The British Horse Society

**Planning Ref 18/00825/HYBRID – Application re-consultation, Heyford Park**

**1. Walking and Cycling Strategy (Figure 5.1/Rev C dated 25/06/20)**

FIGURE 9 PEDESTRIAN AND CYCLE CONNECTIONS

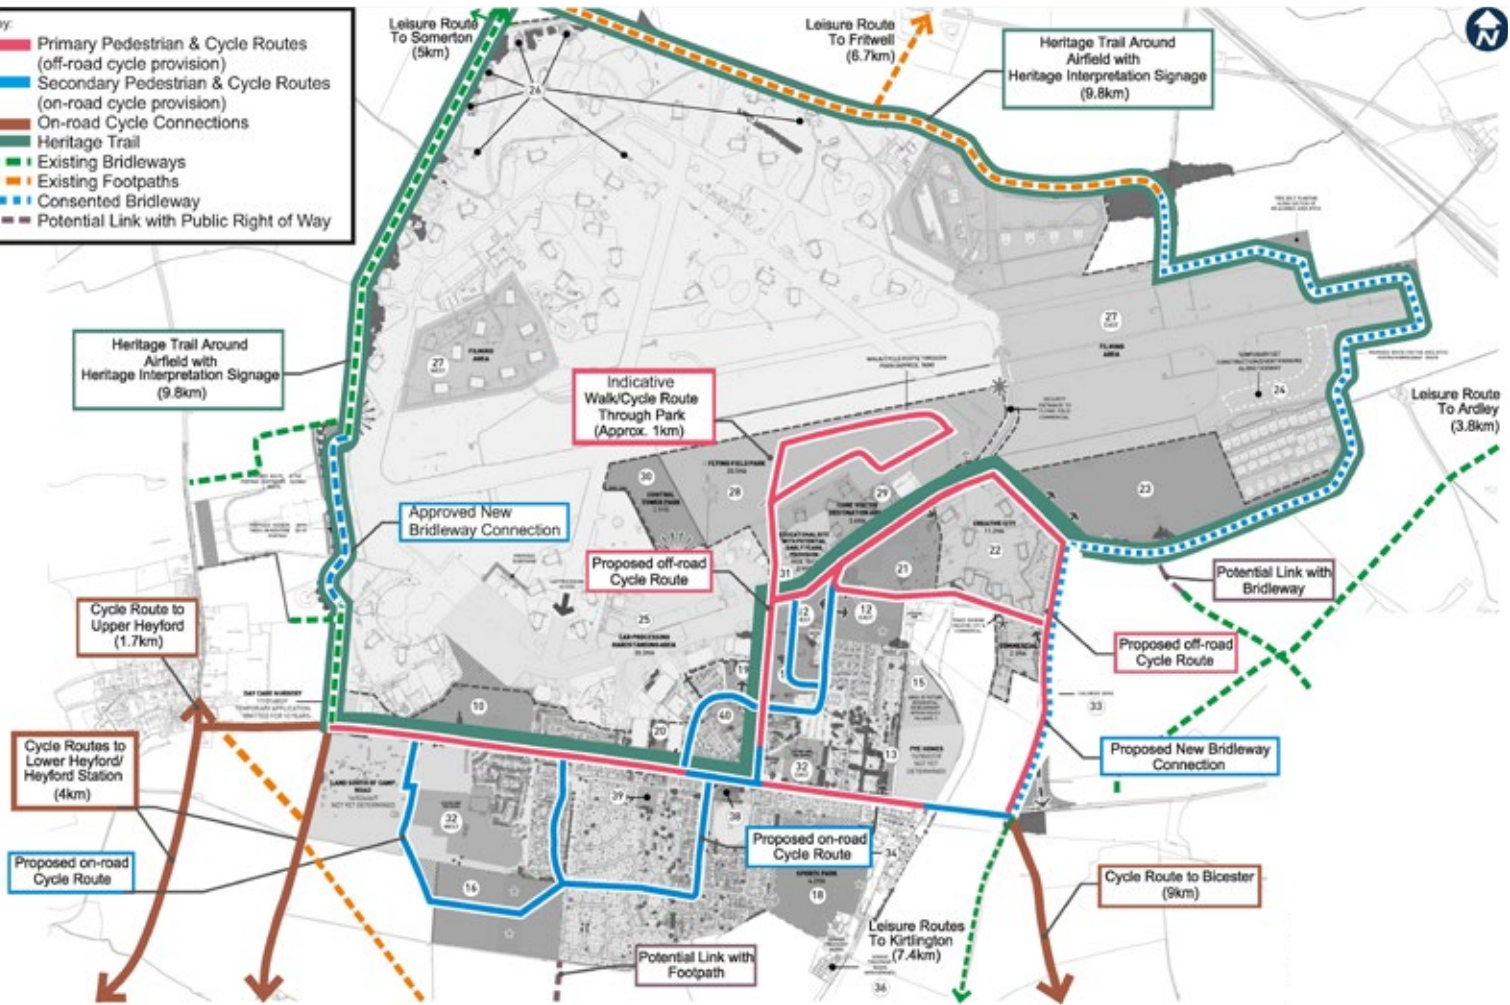
The BHS welcomes the inclusion in this latest Plan of a Pegasus crossing of Camp Road between Upper Heyford Bridleway 7 on the south side and the new bridleway link alongside Chilgrove Drive to the north, in line with our earlier comments of 12 February 2020.

We ask that our other recommendations regarding both the Aves Ditch and Portway bridleways are included as Planning Conditions, should permission for this development be granted. We also ask that the Society be consulted on the detailed specifications for both these paths prior to implementation.
